Richard Temple; 'Alex Budd'; Tim Townsend  
**Subject:** RE: Wings Nursery

Thank you for your email in relation to AL/115/17/OUT and sorry for not responding sooner.

I write to you in reference to planning application AL/115/17/OUT for a 55 dwelling residential development and associated access on land to the west of the A29 Lidsey Road, Woodgate, West Sussex. My colleague Alex Budd has been handling this project but I now feel compelled to write to you.

SMO	ALB	PMR
December 2017	2017/3711/001	C

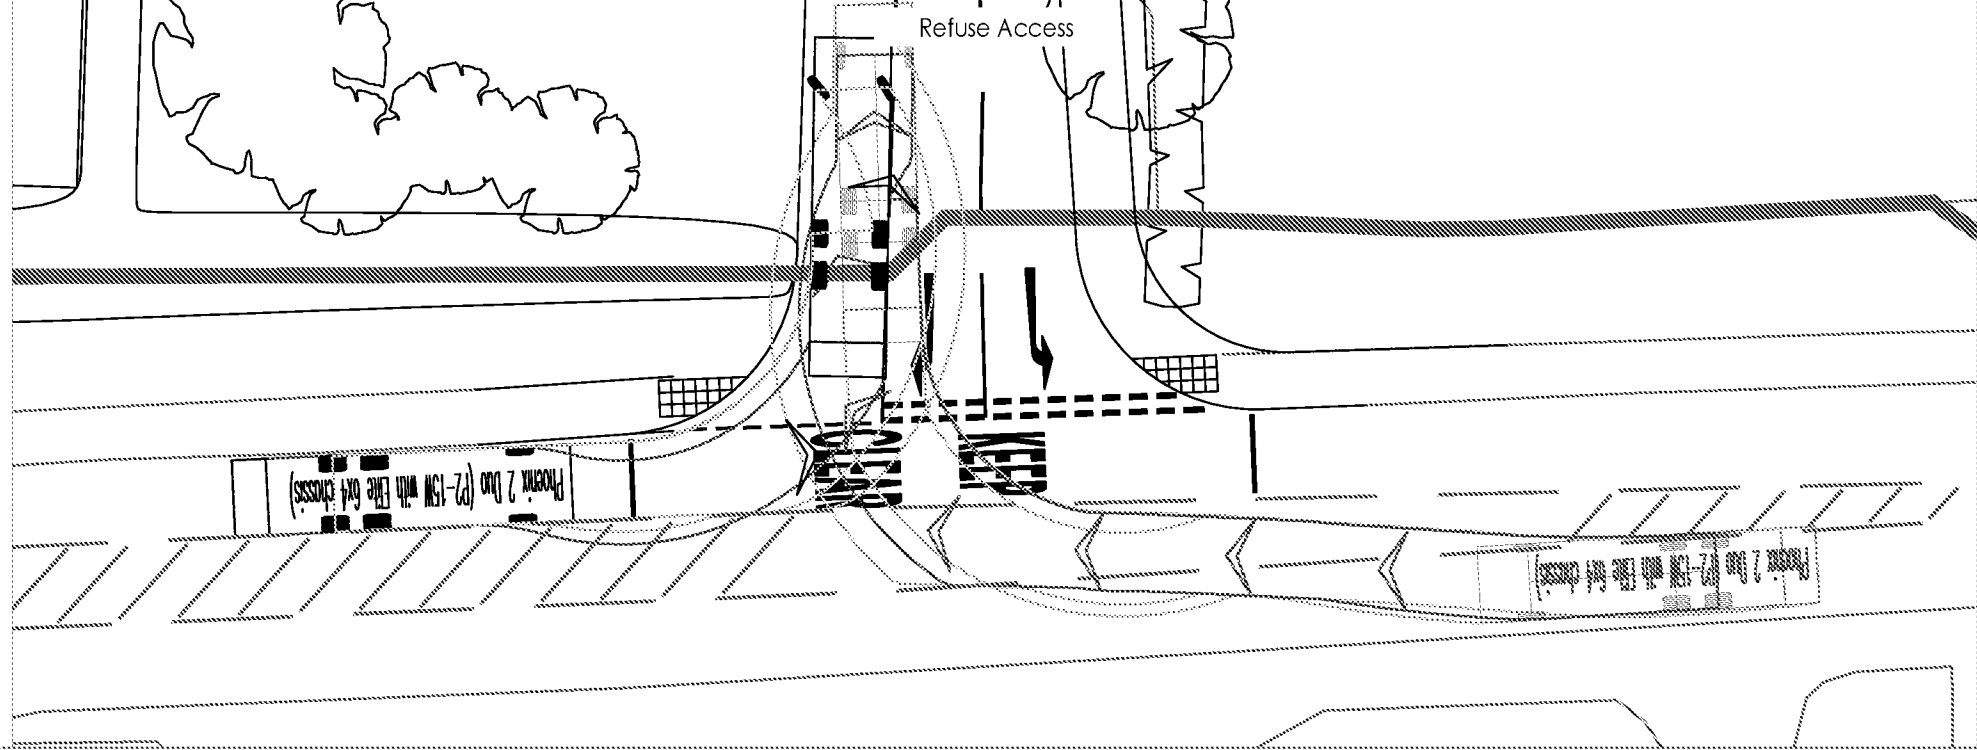
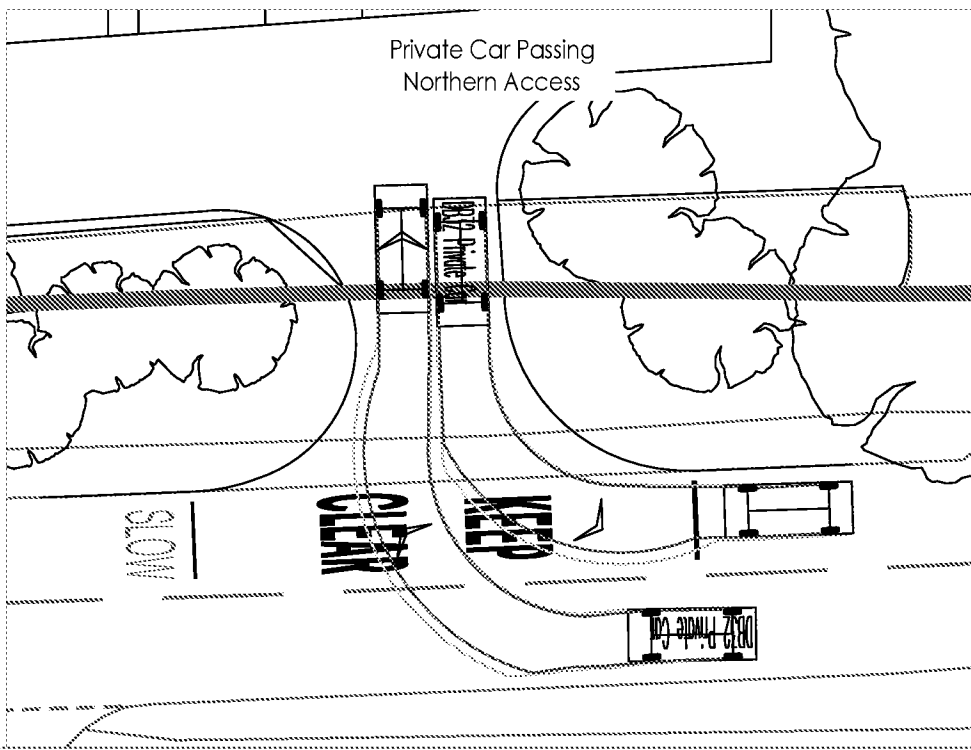
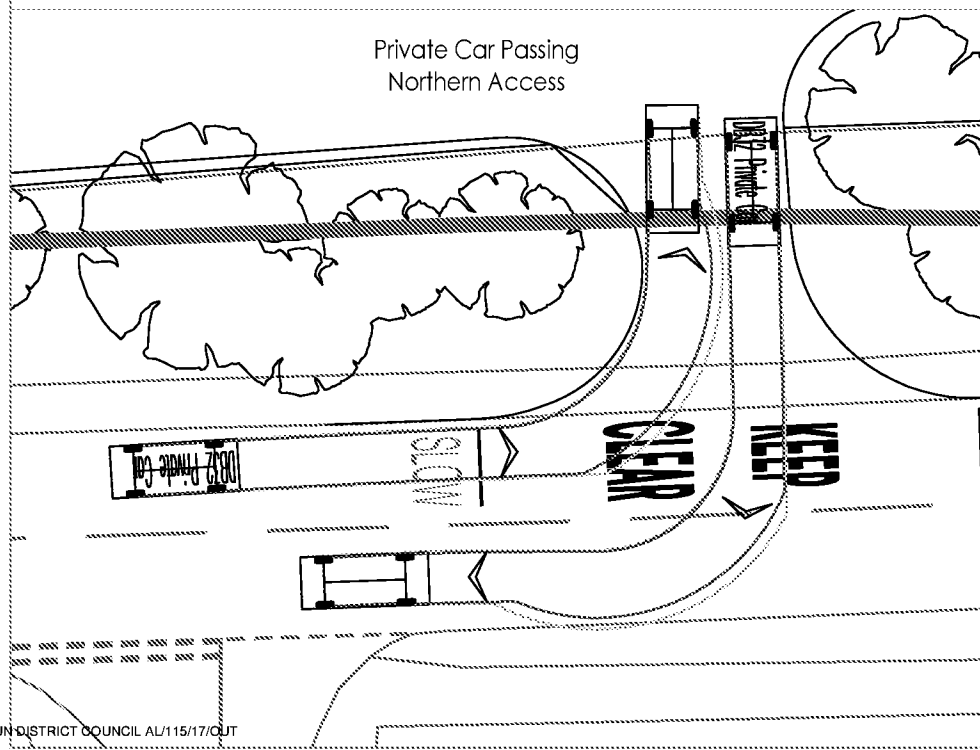
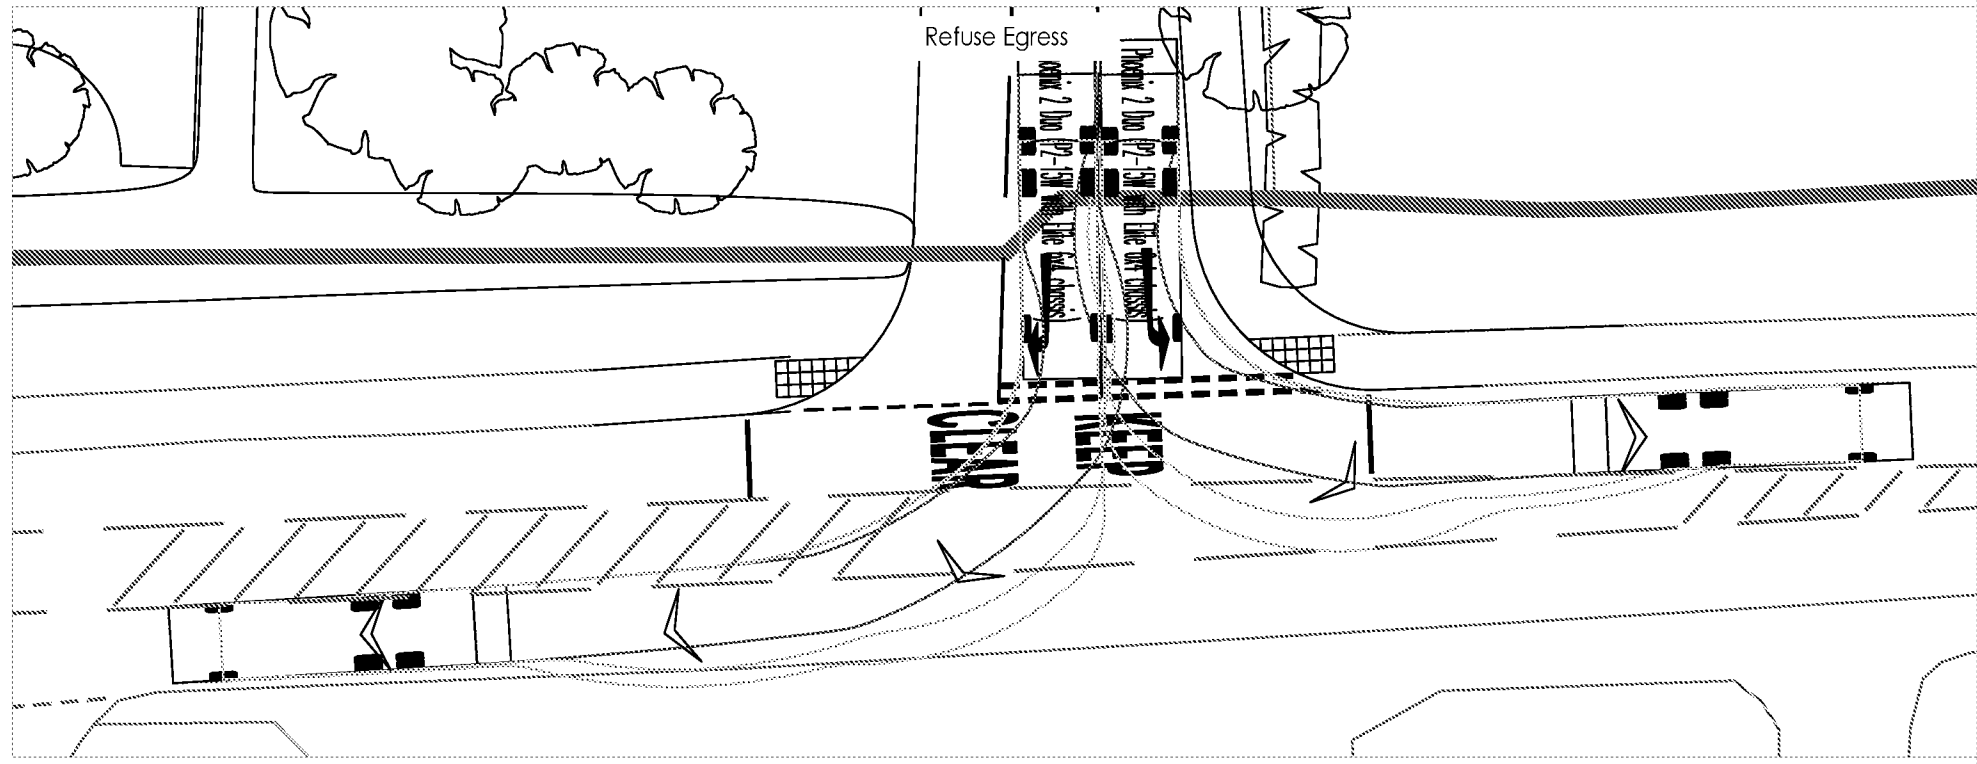
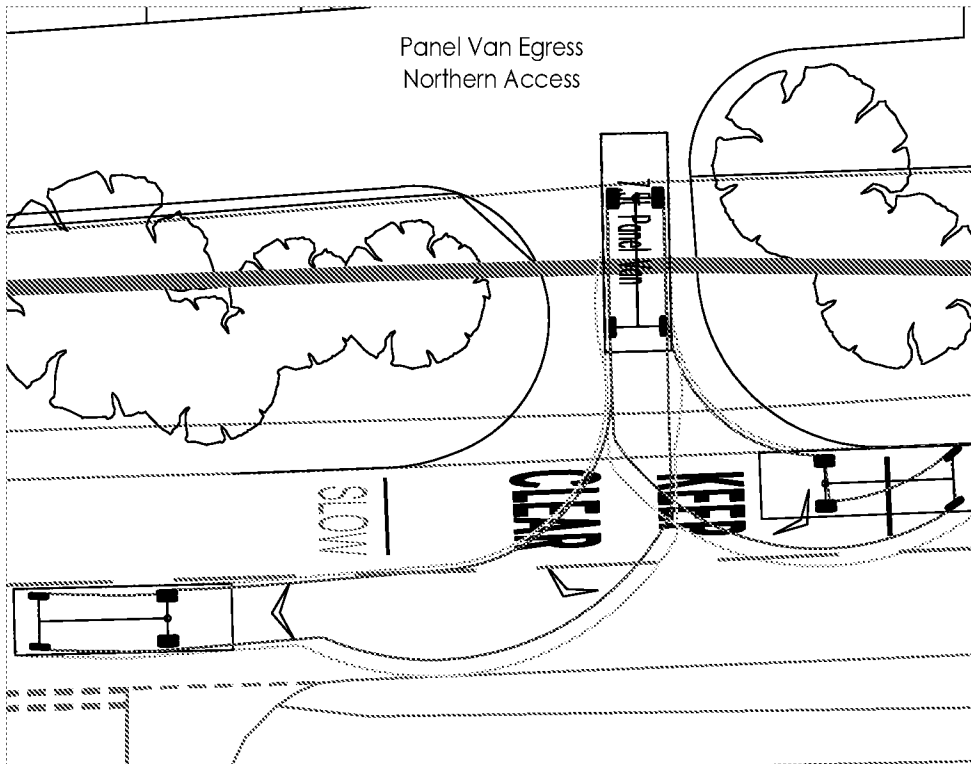
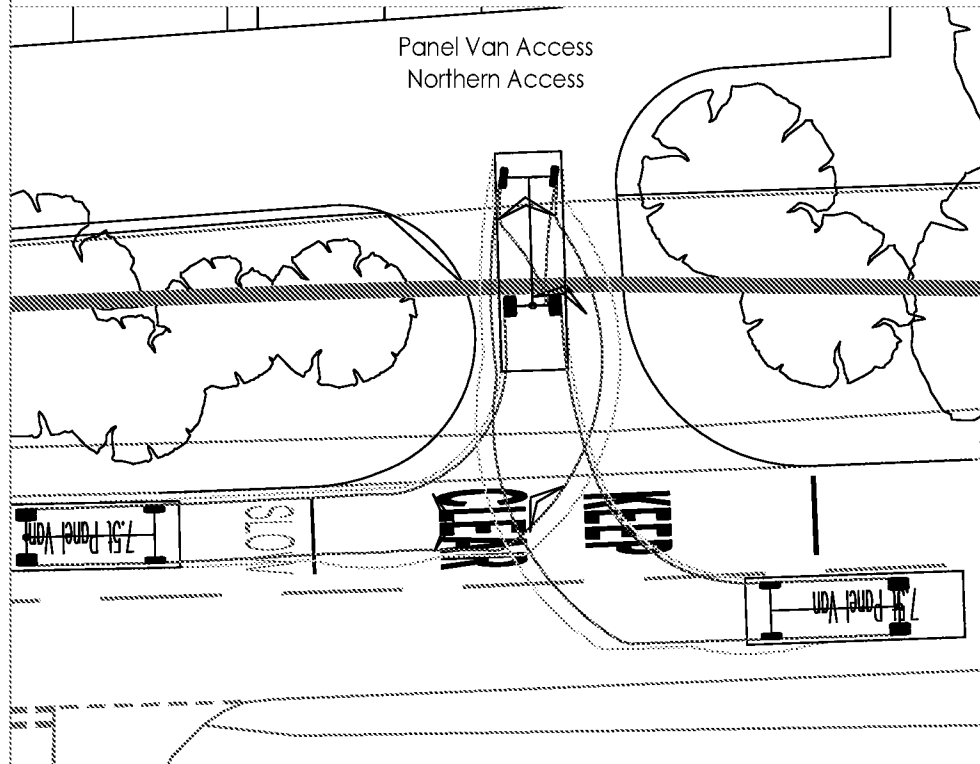
In relation to other concerns about the site access which specifically relate to its design the Highway Authority would look for a design review of these highway works to be completed with reference made to how they meet the standards contained within the Design Manual for Roads & Bridges (DMRB) and highlight any departures from standard. Whether or not we agree whether use of the DMRB or the Manual for Streets is the most appropriate for this location is irrelevant, as Tim has previously stated and as you are aware, MfS does not include designs for right turn

pockets. The points made in bullet point 4 on page 4 of the Highway Authority comments remain valid and need to be considered as part of this design review. It is noted that in the Dec 2017 Technical Note revised access arrangements have been proposed which include a two lane exit from the site and keep clear markings on both access points. I will also ask one of our engineers to review the access arrangements and provide any comments we have in relation to the design. Any revised design should also be passed to the Safety Auditors who carried out the Stage 1 Audit for further comments. Should they decide to make further recommendations, an updated Designer's Response will also be necessary.
